**The Old Post Office
Main Street
Sibford Ferris
Banbury
OX15 5RG**

17/02373/LB

Proposal: Erection of second storey extension to an existing single storey utility room with the renovation of the current rear ancillary buildings.

Proposed First Floor Plan
 170182 - A - FF - 110

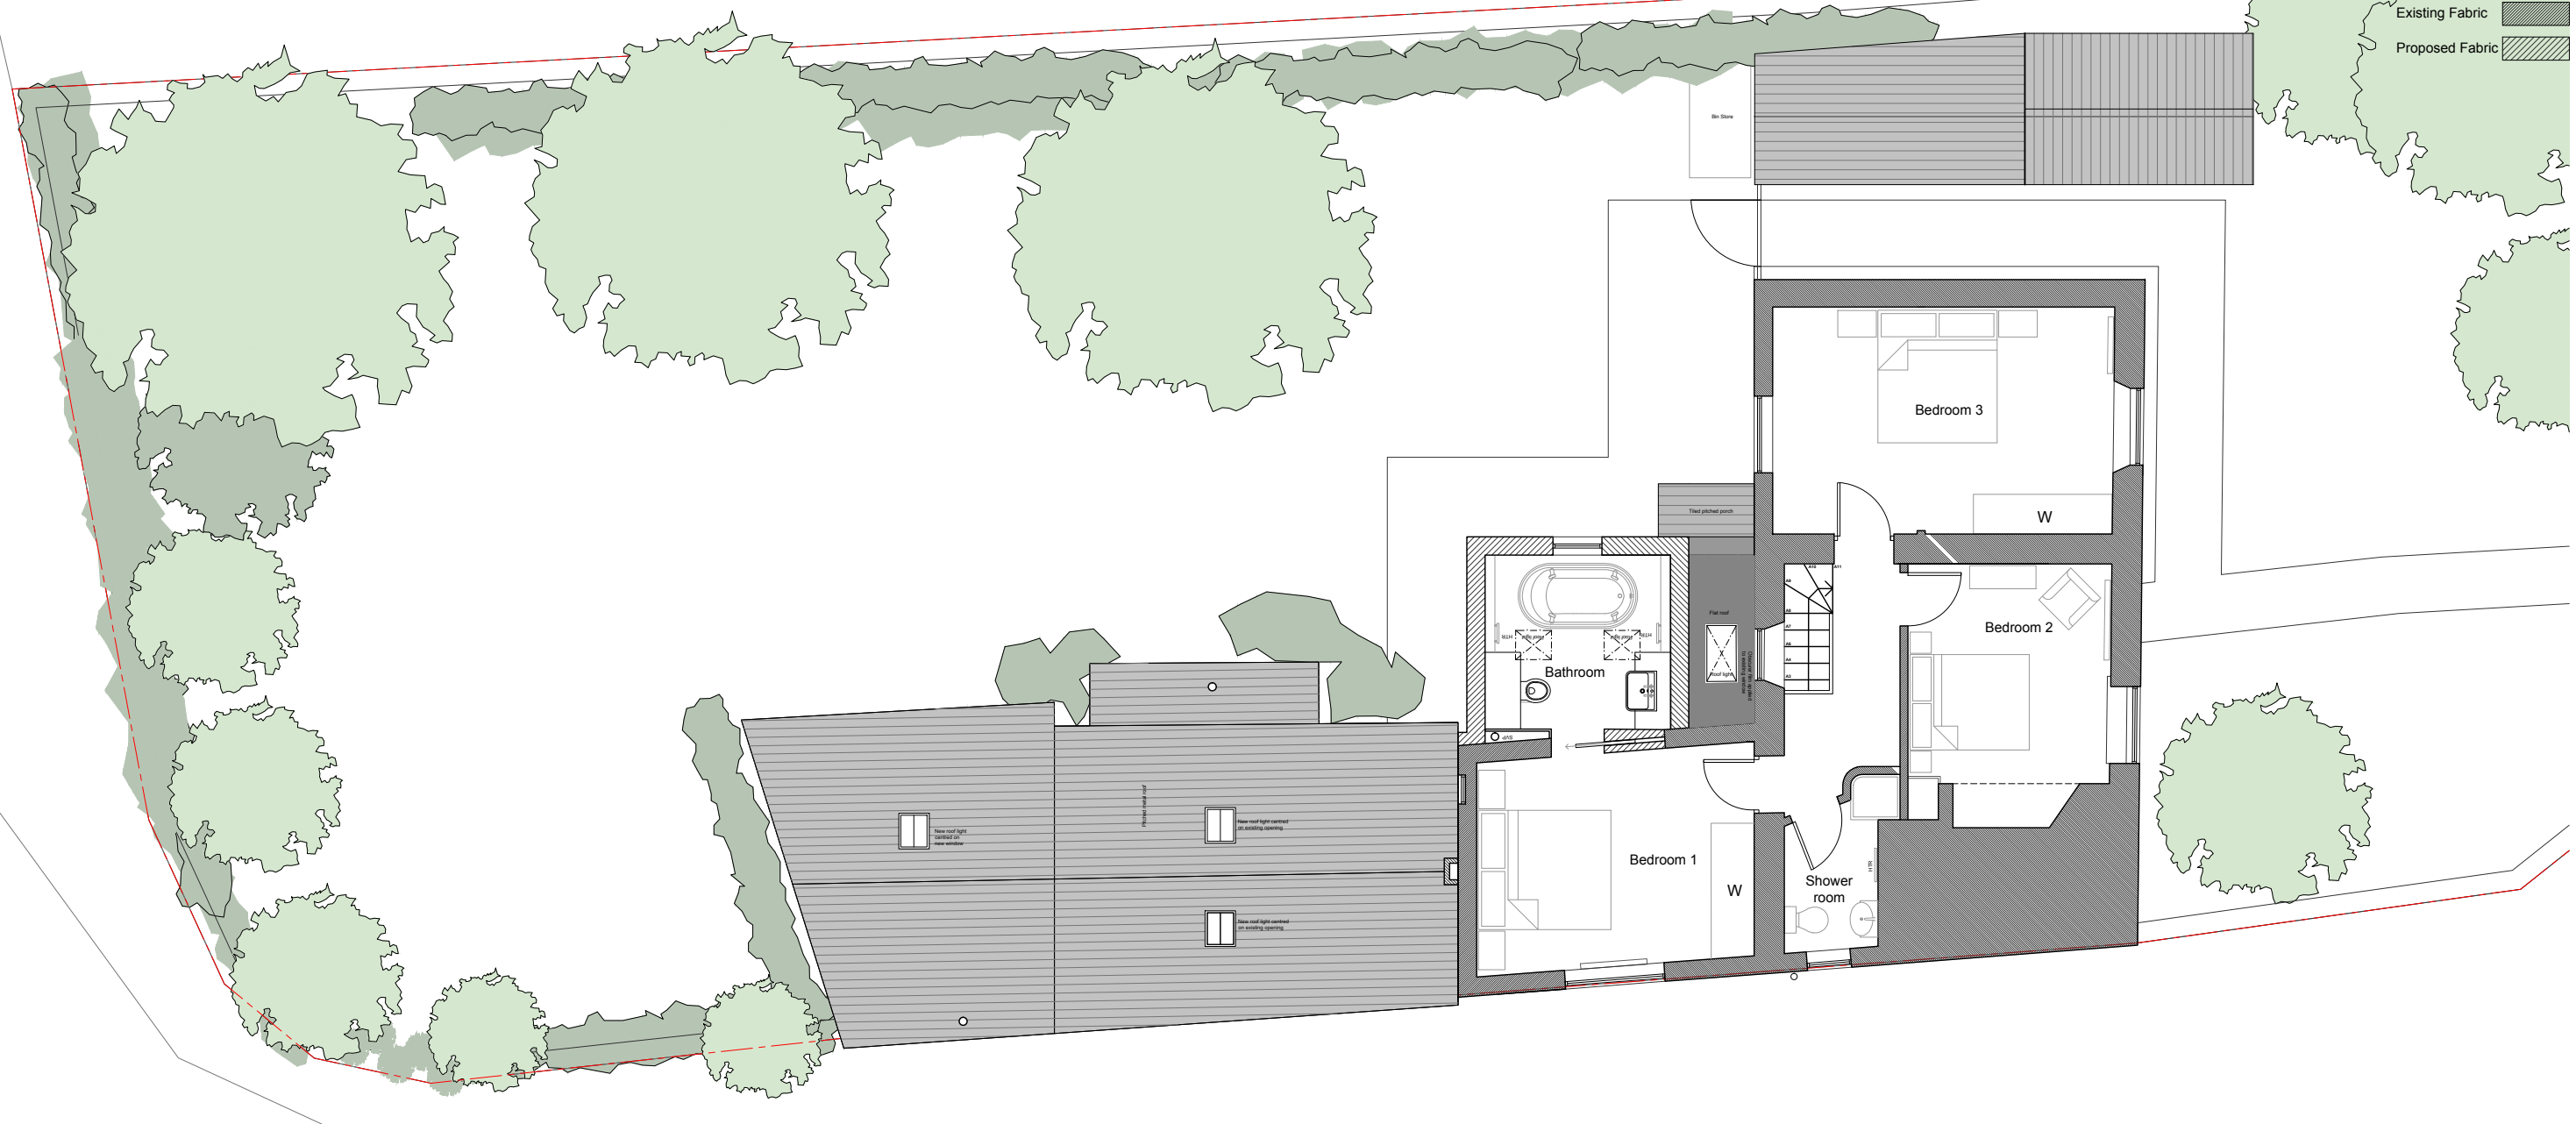
- 2.2. The proposed extension would form a 1st floor bathroom and measure 3.1m by 3.6m. The proposal would have a pitched roof with a ridge and eave height of 5.4m and 3.5m respectively. One 1st floor window is proposed for the eastern elevation and 1 No. roof light is proposed for both the northern & southern roof slope.

“There would usually be concerns with adding an additional storey to a building such as this as it alters the essential plan form of the building. In this instance, however, there is precedent for a structure in this location and the additional storey has been constructed in a way that it does not impact on the plan form or historic fabric of the principal listed building. The proposed development has a traditional appearance that is in-keeping with the vernacular style of the building, albeit that there have been changes over time. The proposed development is considered acceptable in this instance.
